Bike Leichhardt

September 16, 2019

Submission on Modified EIS - SSI 7485

Figure 4-5 The Crescent/Johnston Street/Chapman Road intersection

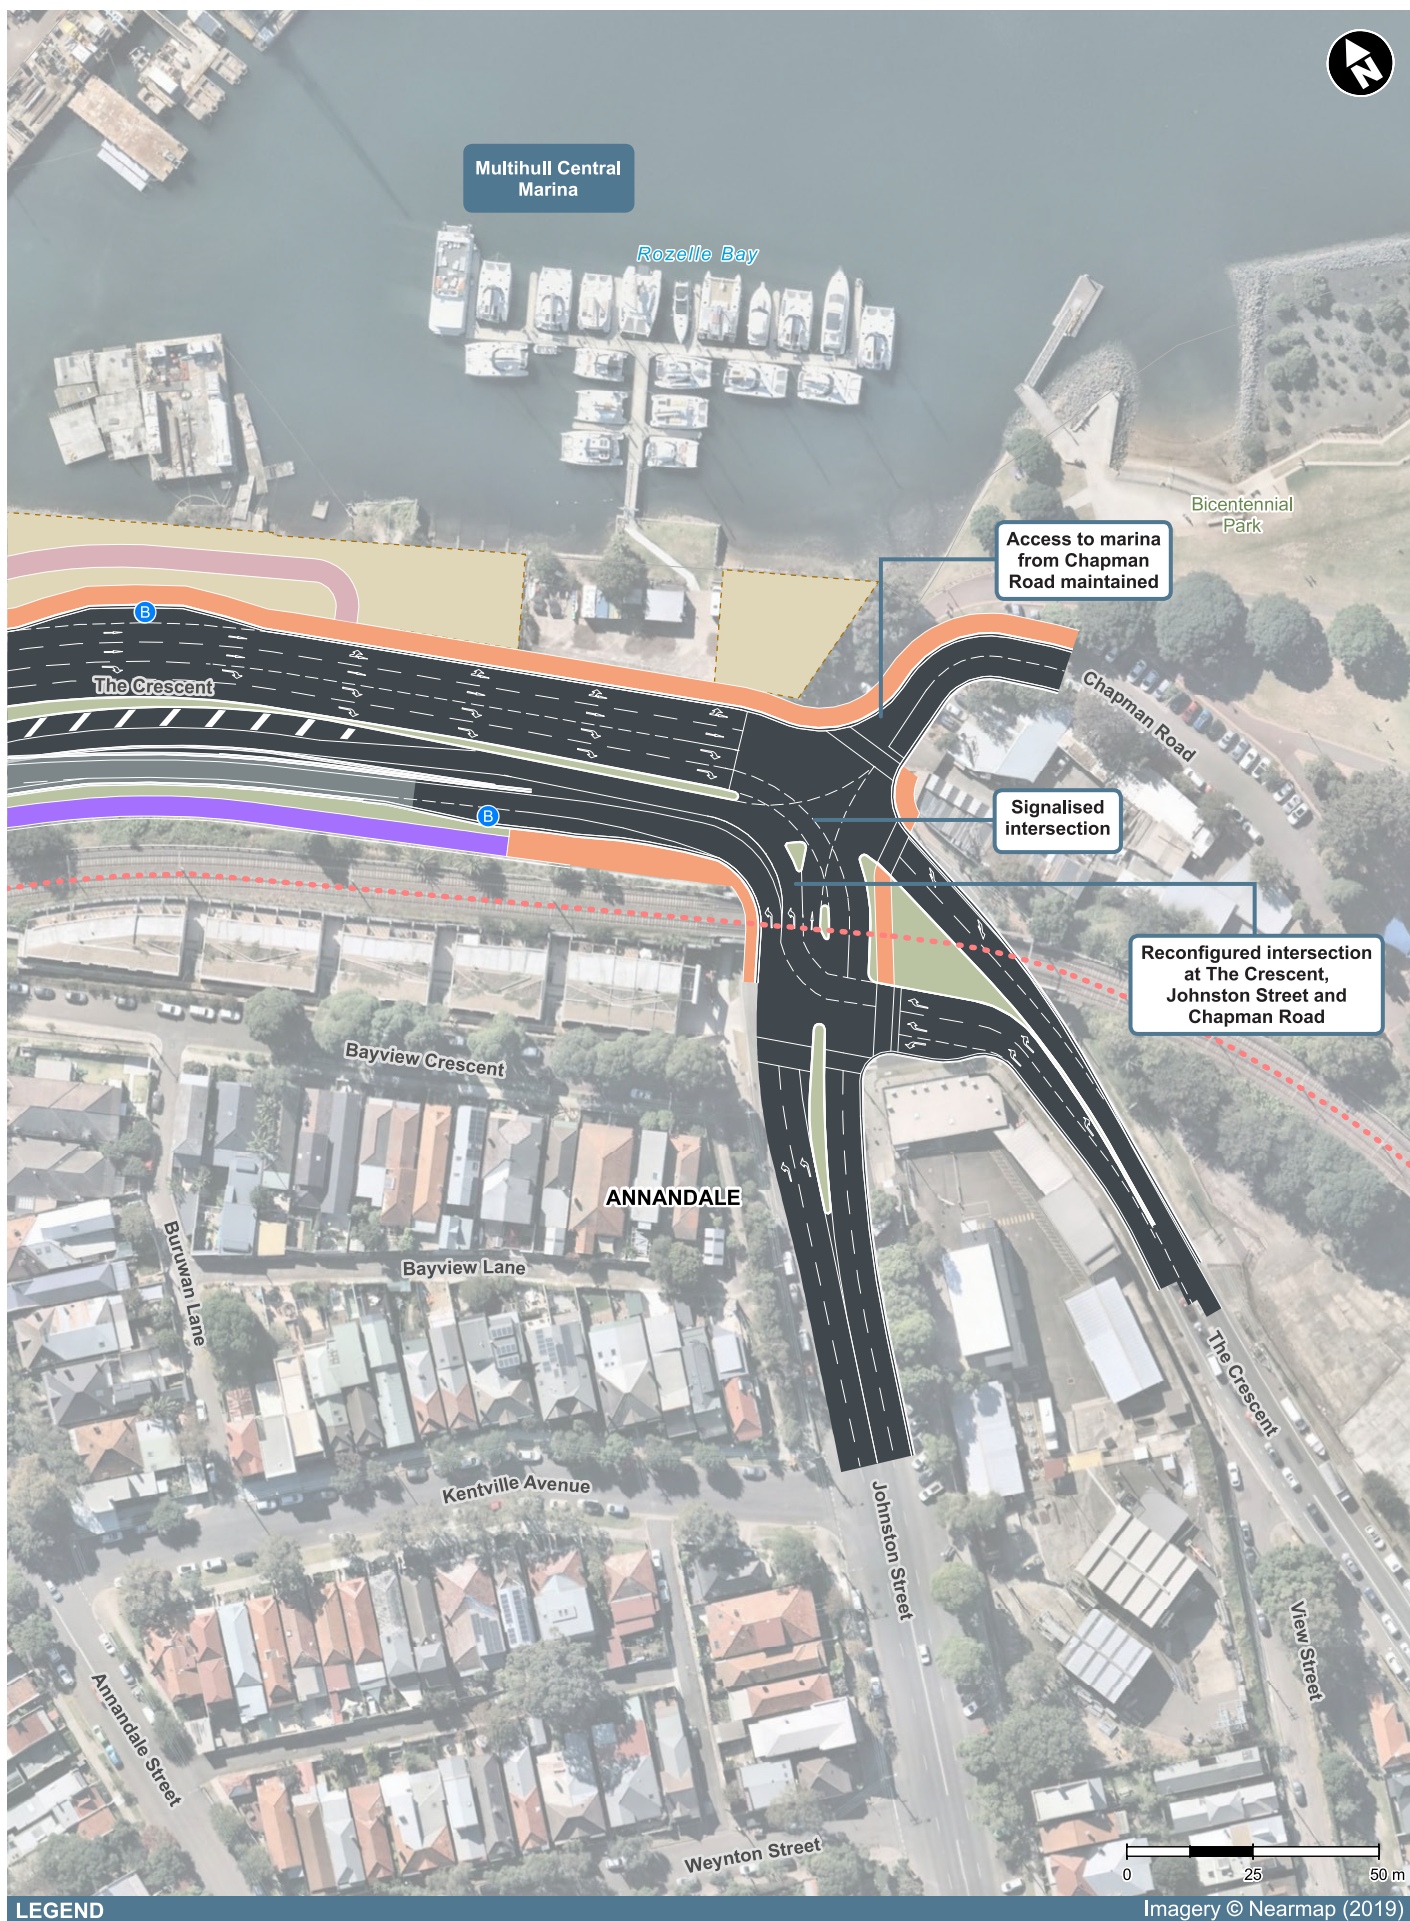
We see Johnston St as being important for access to Annandale and note that there is nothing in the modified EIS to assist cyclists to use this street. An existing bike lane on the northbound side leading to The Crescent appears to have been replaced with a traffic lane. We request that a shared path or bike path be instituted between The Crescent and Rose St, to provide an easier gradient into Annandale, Kentville being steep.

Similarly on the southbound side of Johnston, a bike lane uphill or a shared path should be included or allowed for from The Crescent. Some angle parking could be removed to allow this. We note that requirement 60 in the EIS for a Bicycle Implementation Strategy could include works on Johnston St. It was a long term goal of the the former Leichhardt Council to provide a bike path or lanes along Johnston St.

Cyclists may also decide to use the existing pedestrian refuge on The Crescent, opposite the new skate park, to get to and from the City of Sydney parklands (and the Chapman Rd bike route) and Johnston St. We request that shared paths be instituted on The Crescent and around the slip road to Johnston St.

The lights at Johnston St and The Crescent should also have bicycle lanterns.

Figure 4-6 Elevation: Indicative view of Rozelle Rail Yards Pedestrian and Cycling Green Link

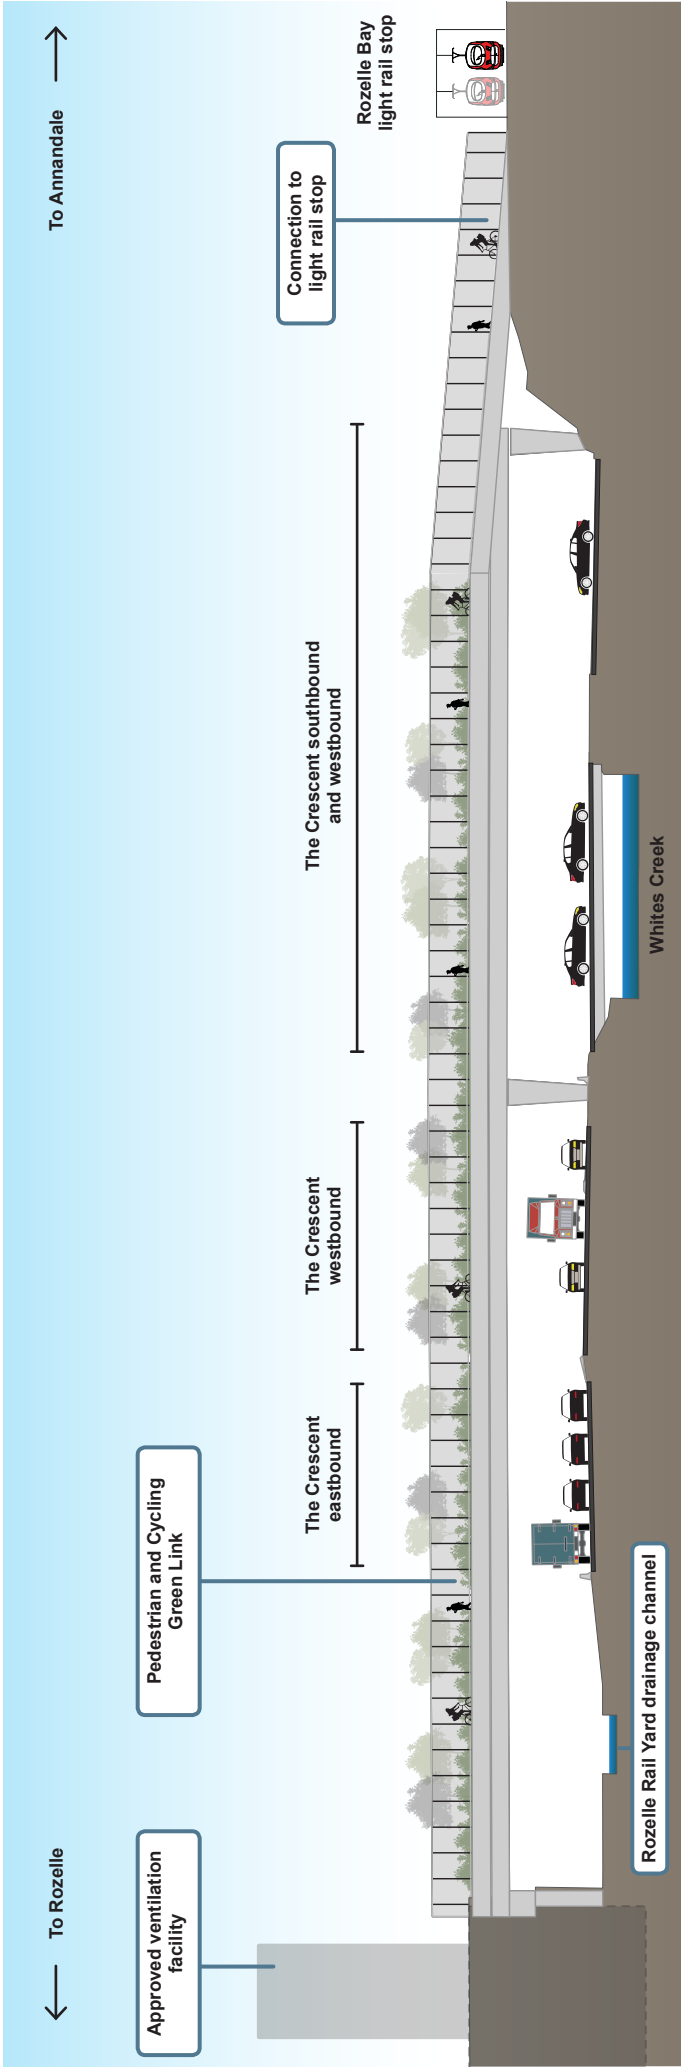
The "Green Link" over The Crescent now no longer provides direct access to the foreshore. Bike Leichhardt can see the reasoning for achieving this instead by the new shared path bridge but we point out that for cyclists coming off the Anzac Bridge via what we hope will be (on the face of it, as no details are available) a path under Victoria Rd and along the linear Railyard Park this will be a long detour, first to the west then curling back to the new bridge. We would urge you to investigate a more direct connection, in more of a straight line from Victoria Rd underpass to the new crossing of City West Link to the foreshore path, recognising that a long ramp will be required to attain bridge level. Alternatively an underpass could be provided.

We also deplore the loss of Buruwan Park and the at-grade connection to Railway Pde and consider the Green Link a poor substitute, overshadowed by the flyover. We request that an at-grade shared path link be retained from the Railway Pde rail underpass, along the new line of The Crescent, next to the Mural, to Johnston St. We do note that there will be a multi phase

Some cyclists using the Green Link will naturally want to descend to The Crescent level via the proposed pedestrian ramp, shown in purple on the diagrams. We can see this leading to conflict and enforcement issues and say that it would be much better if it was designed as a shared path.

Cyclists using the Green Link will also probably have to dismount to cross the light rail, and enforcement issues will arise. In our view it is safe to ride across the light rail if cyclists stop and look.

The gradient up to the light rail level from Railway Pde is quite steep, which will be a disincentive to those cyclists using Railway Pde from Leichhardt and Whites Ck areas, hence our request for an at grade connection. The gradient up Pritchard St and Annandale St is also quite steep, so the Green Link will not improve access to Annandale greatly.
